Report of the Head of Planning & Enforcement Services

Address 57 GRANVILLE ROAD HILLINGDON

Development: Conversion of roof space to habitable use involving the erection of a rear dormer window and installation of 2 front rooflights (Application for a Certificate of Lawful Development for a Proposed Development)

LBH Ref Nos: 31252/APP/2010/508

PROPOSED REAR ELEVATION 1:100

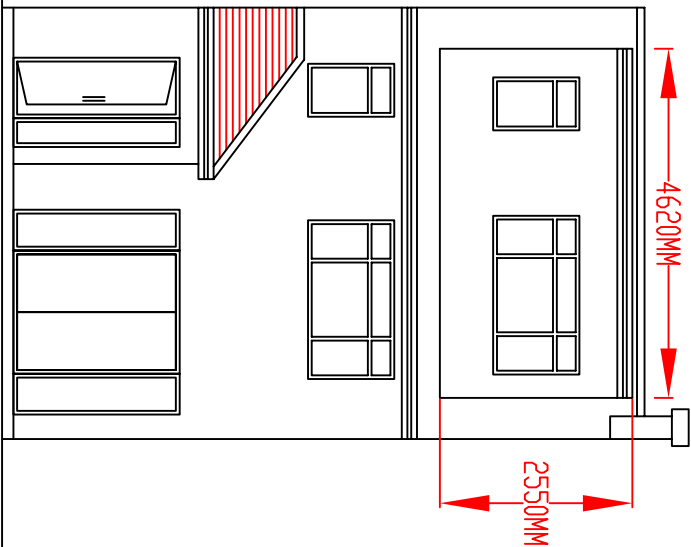
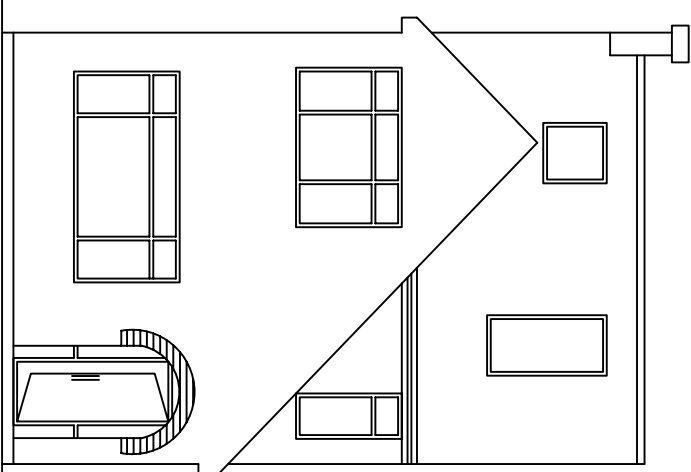
Does any part of the dormer project forward of the plane of a roof which forms a principle elevation and fronts a highway?

NO

Is the enlargement/dormer set in 20cm (200mm) from the roof margins?

YES

SECTION X-X' 1:50

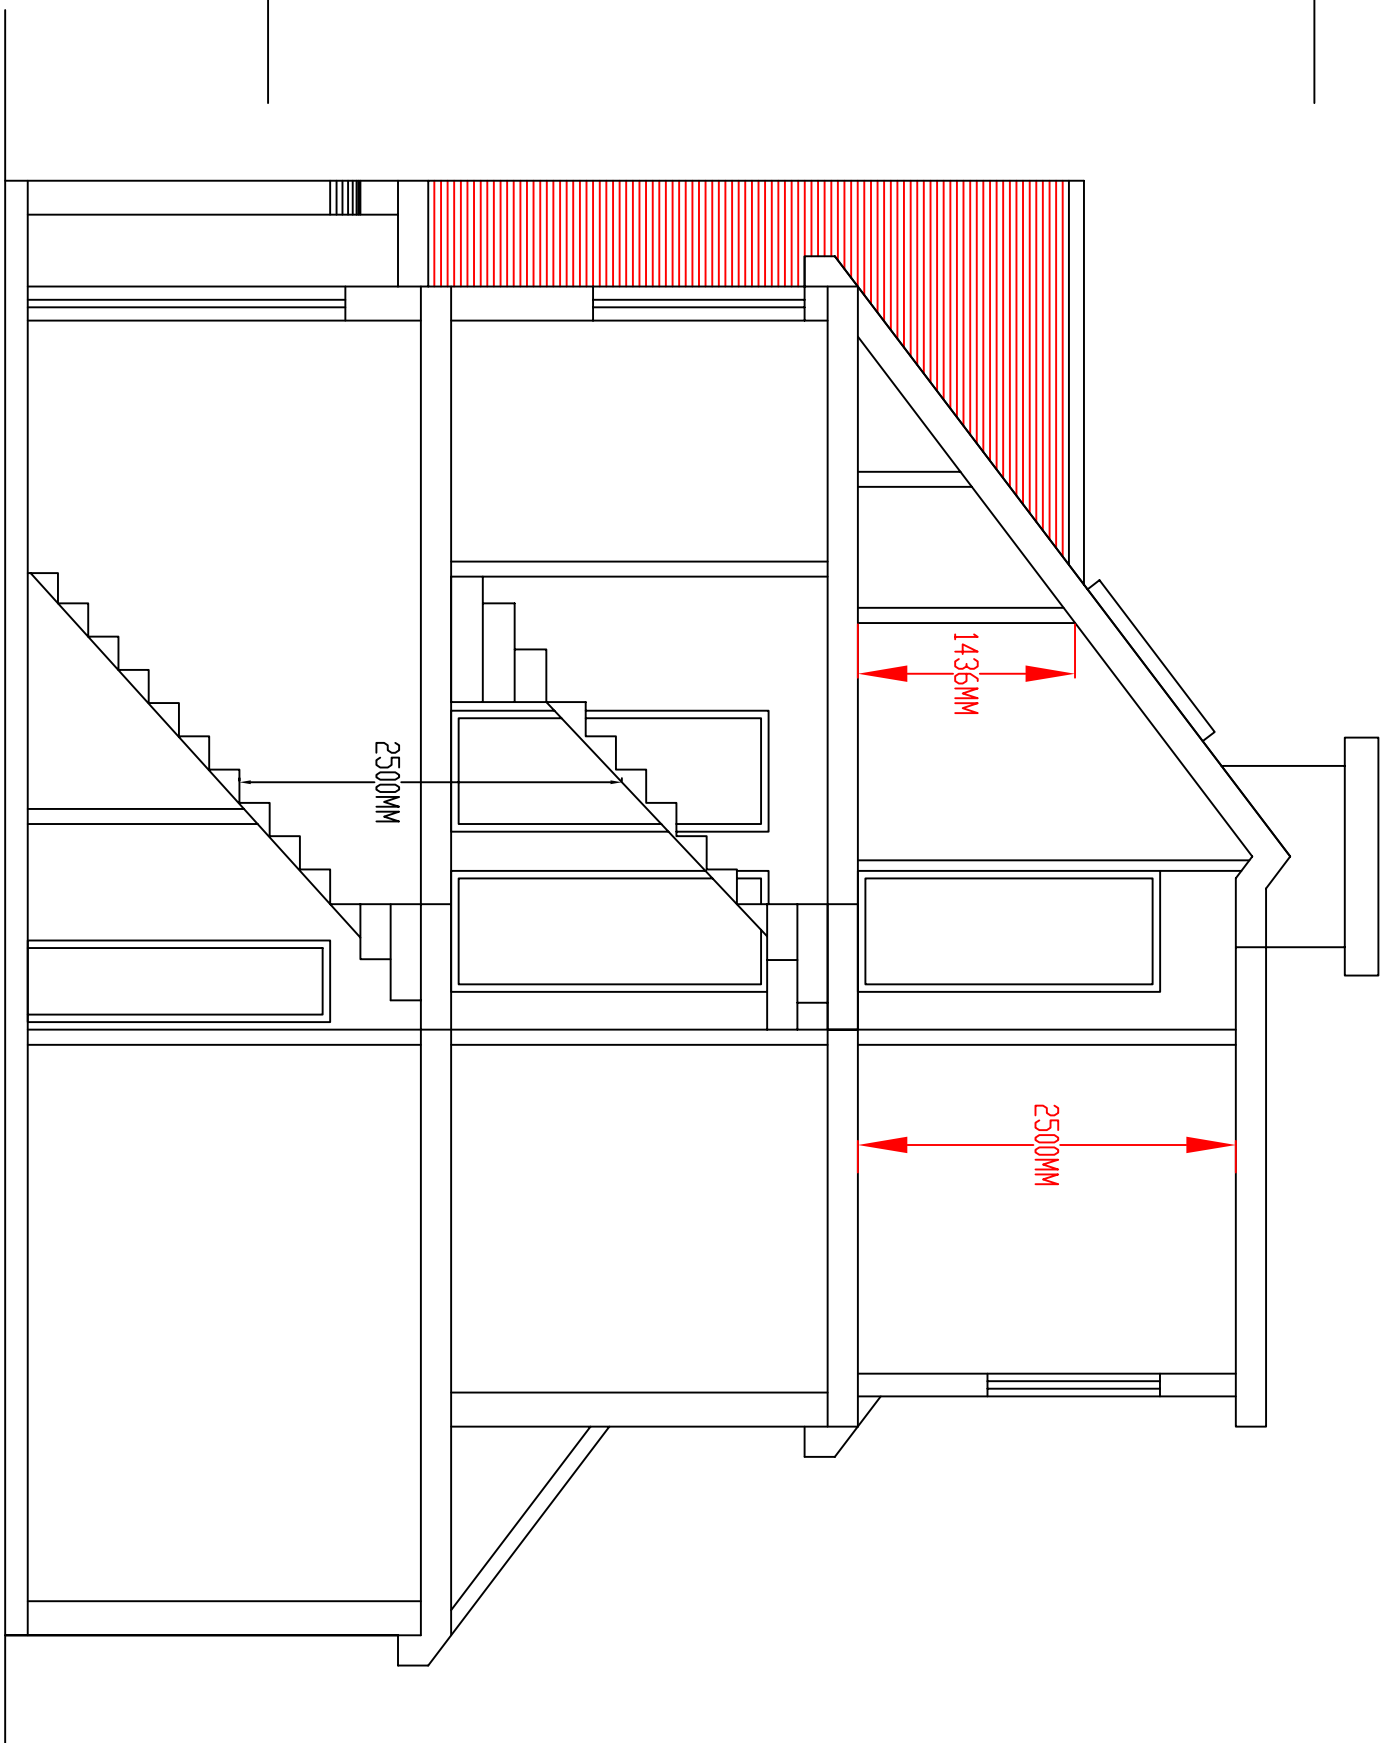
Does the volume of the proposed, and any existing roof extensions, exceed the permitted development allowance?

NO

Dormer

$$0.5 \times 4.62\text{m(w)} \times 3.55\text{m(d)} \times 2.55\text{m(h)} = 21\text{m}^3$$
